REQUEST

Current Zoning: R-8MF(CD) (multi-family, conditional)
Proposed Zoning: N1-A(CD) (neighborhood 1-A, conditional)

Approximately 26.17 acres located on the west side of Beatties Ford Road and north side of Kidd Lane, south of Miranda Road.

The petition proposes to develop a residential subdivision made up of single-family, duplex, and triplex dwellings on a site currently developed with two single-family houses.

RZ-1

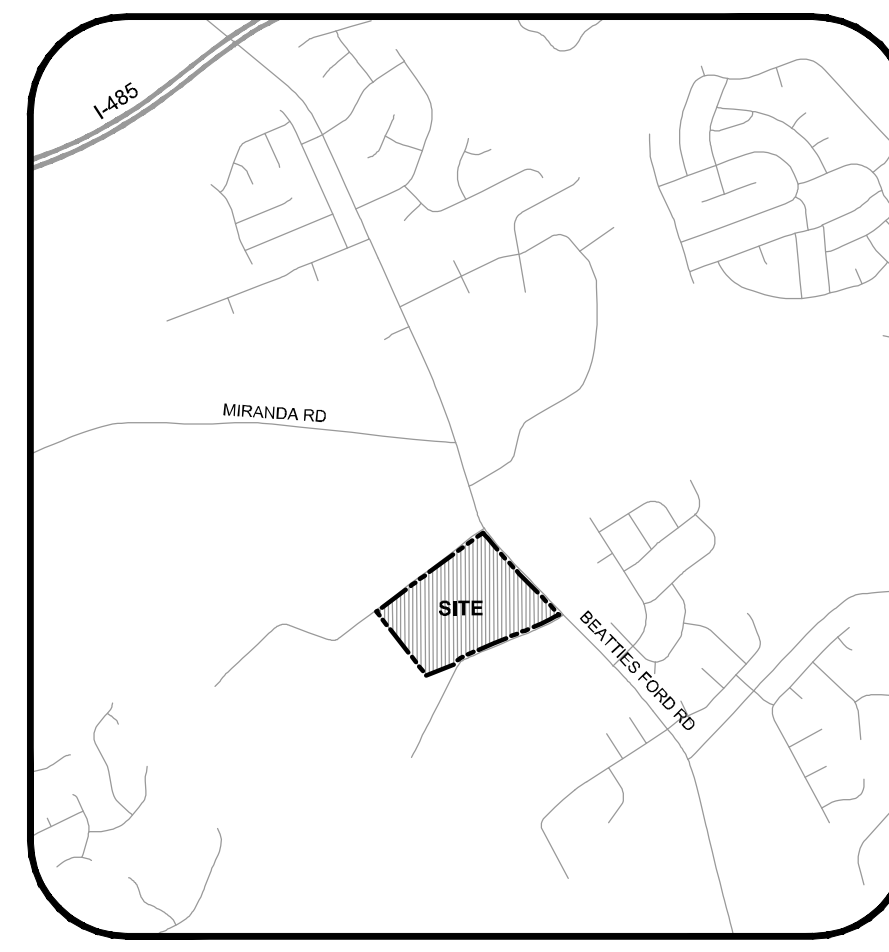
2. Urban Forestry: Tree Survey for Conditional Zoning Map Amendment. A tree survey shall be required for all conditional zoning map amendments.
3. Urban Forestry: Show green area calculations. It does not appear that enough tree save is being set aside.

8. Entitlement Services: Clearly show that the plan meets all Common Open Space and Green Area requirement for Compact Development.

9. Urban Forestry: for purposes of green area right-of-way for public street A, B and future Fred D Alexander are not to be deducted from calculations. Dedicated right-of-way along Cowboy Ln, Beatties Ford, and Kidd can be deducted.

SHEET NUMBER
RZ-2

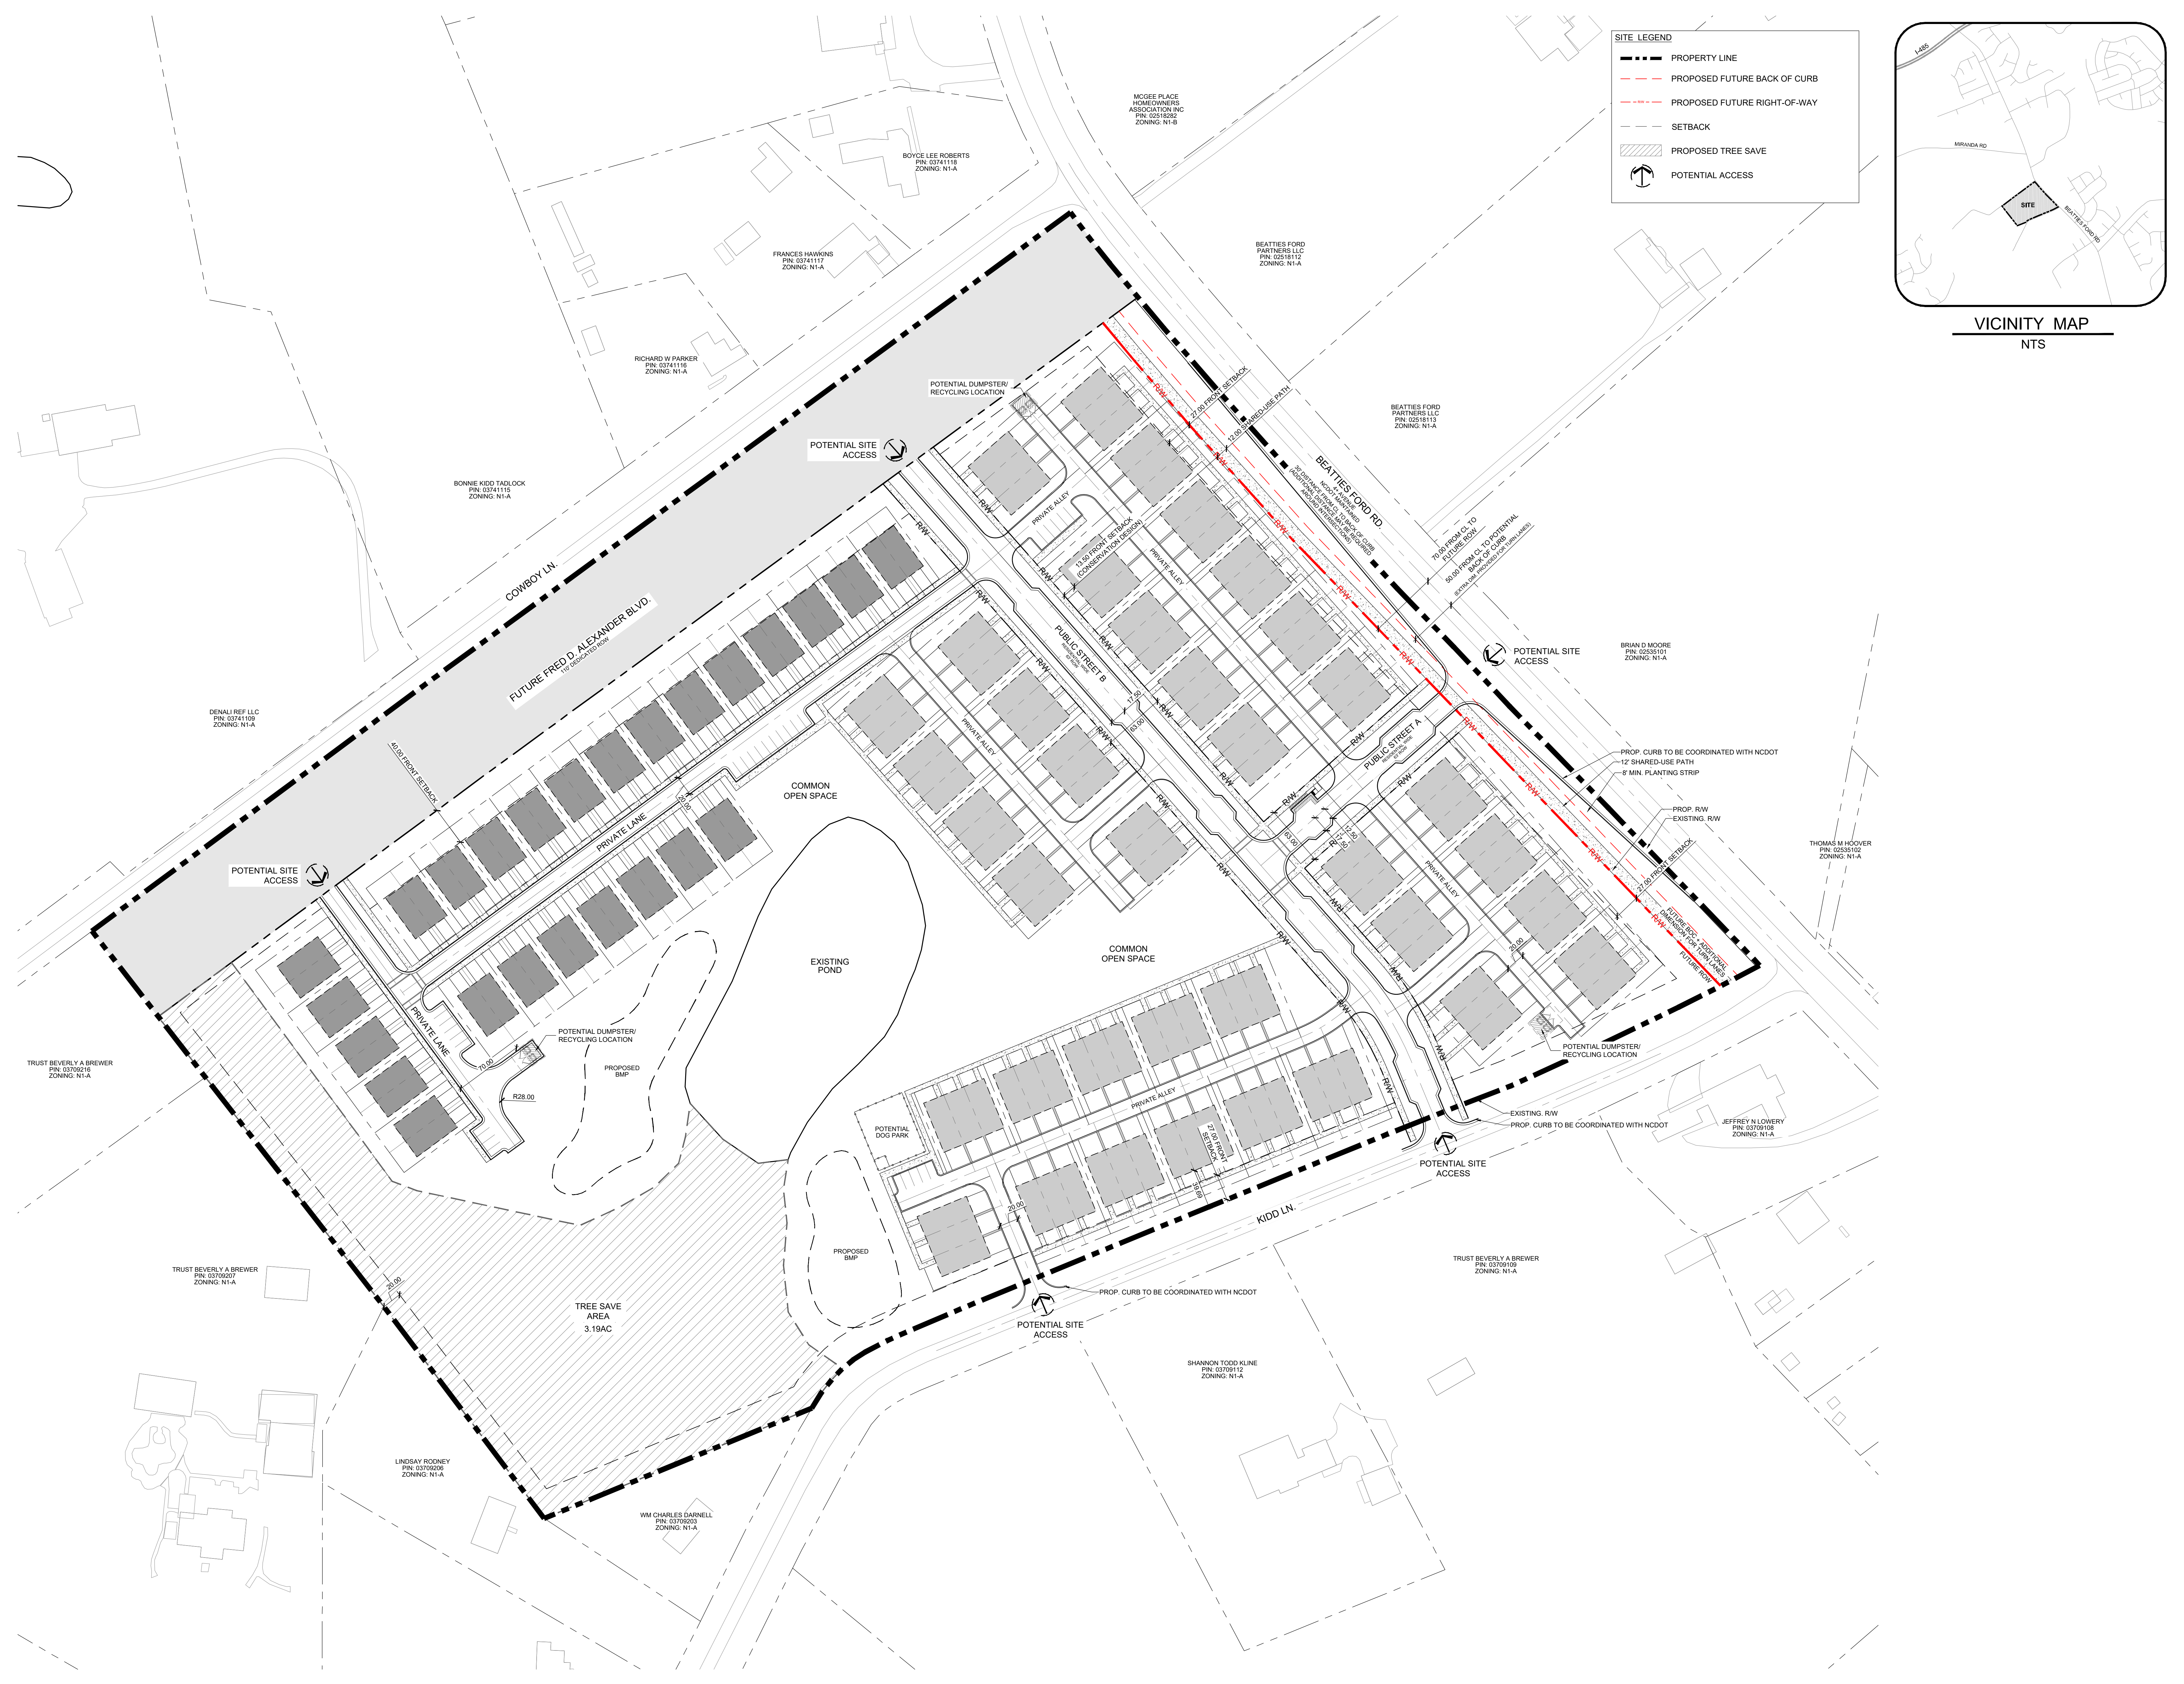
1. CDOT: Site plan and conditional notes should be updated to construct streetscape the entirety of property boundary/Right of way for Kidd Lane and Cowboy Lane as well. Current plan had streetscape stopping short. Continue with streetscape along the entire property boundary for Kidd Lane as shown. Current site plan shows streetscape in its previously proposed location.
